Our Ref: ID 2338
Your Ref: SSD-59006709

2 April 2024

State Significant Development Application for Alexandria Health Centre Detailed Design

Thank you for the opportunity to provide advice on the State Significant Development Application for Alexandria Health Centre Detailed Design at 28-32 Bourke Road, Alexandria. It is understood that the proposed development seeks to undertake:

Drawing Title
BASEMENT GENERAL ARRANGEMENT PLAN

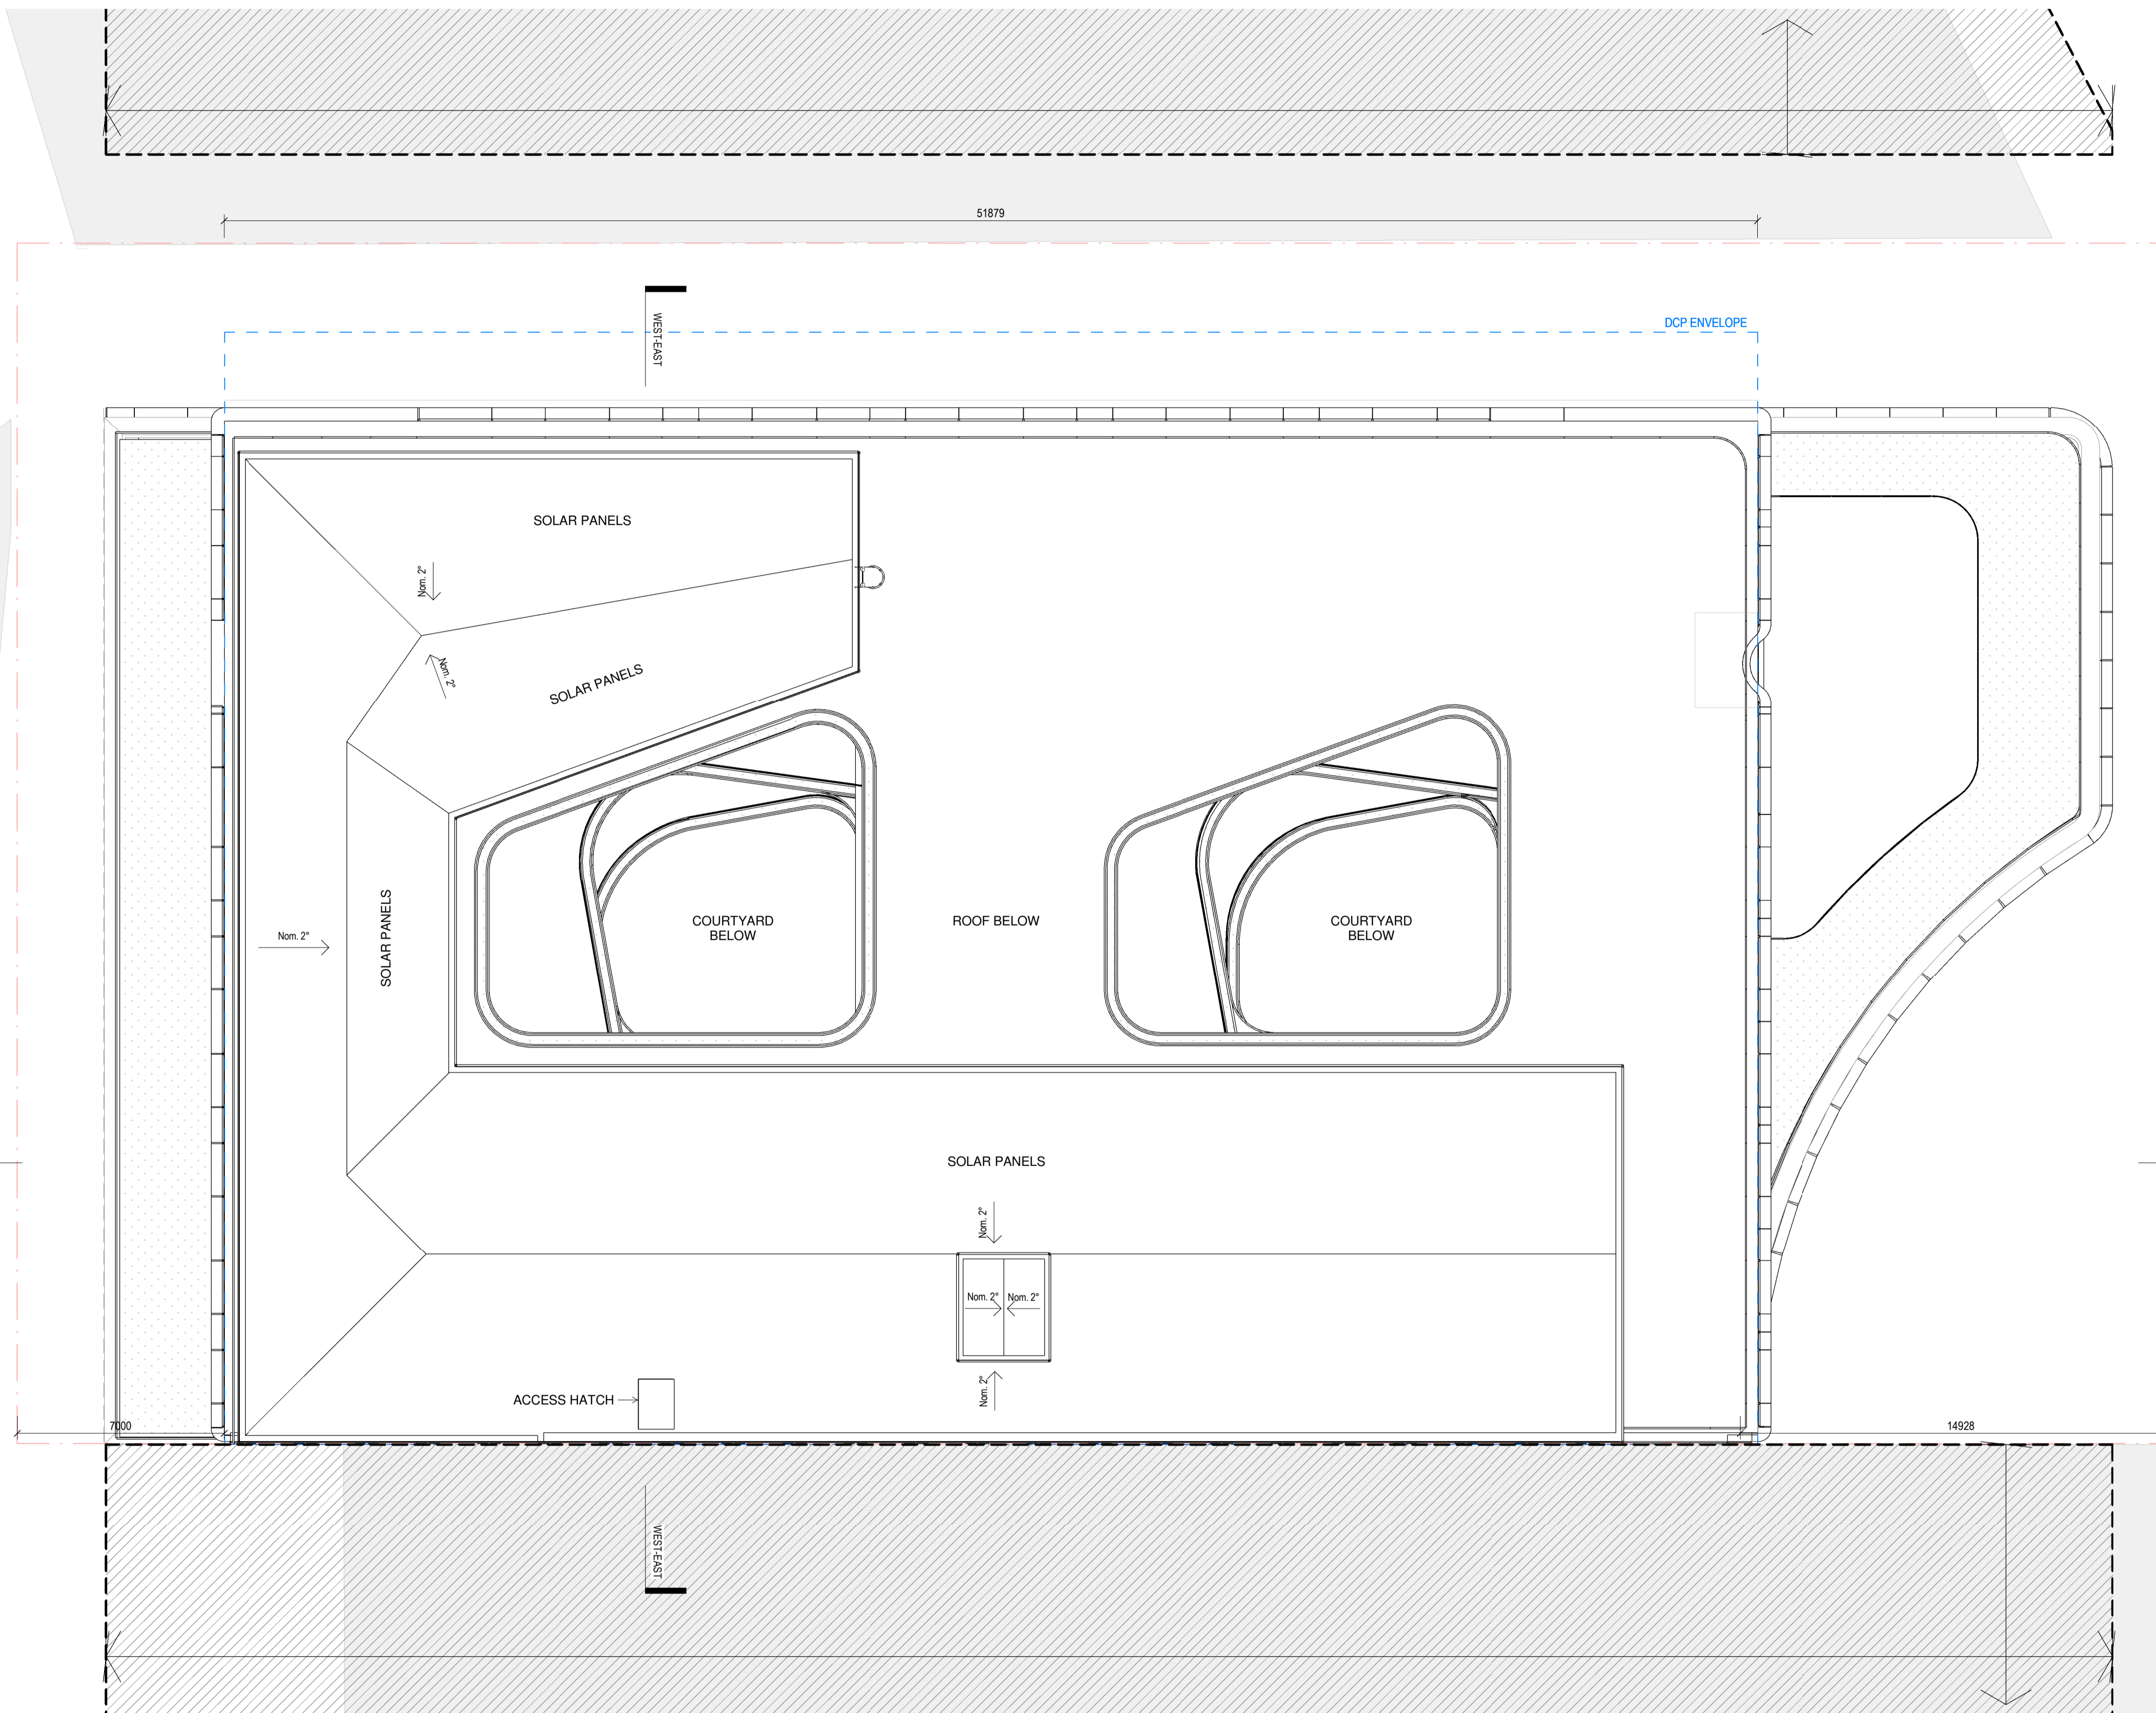
- **Recommend** consideration is given to preventing egress from basement parking into flooded streets.
- **Request** that references to ‘Evacuation Warning (SES)’ are removed for the Operational Flood Emergency Plan. The Australian Warning System uses three categories of hazard warnings: Advice, Watch and Act, and Emergency Warning. These categories replace the previous terminology such as Evacuation Warnings and Evacuation Orders. In addition, due to the short timeframe available prior to the onset of flooding and that there is no official flood warning service for the area, orderly evacuation is unlikely to be feasible from the site. Further information can be found on the NSW SES website at <https://www.ses.nsw.gov.au/about-us/our-warnings/>.
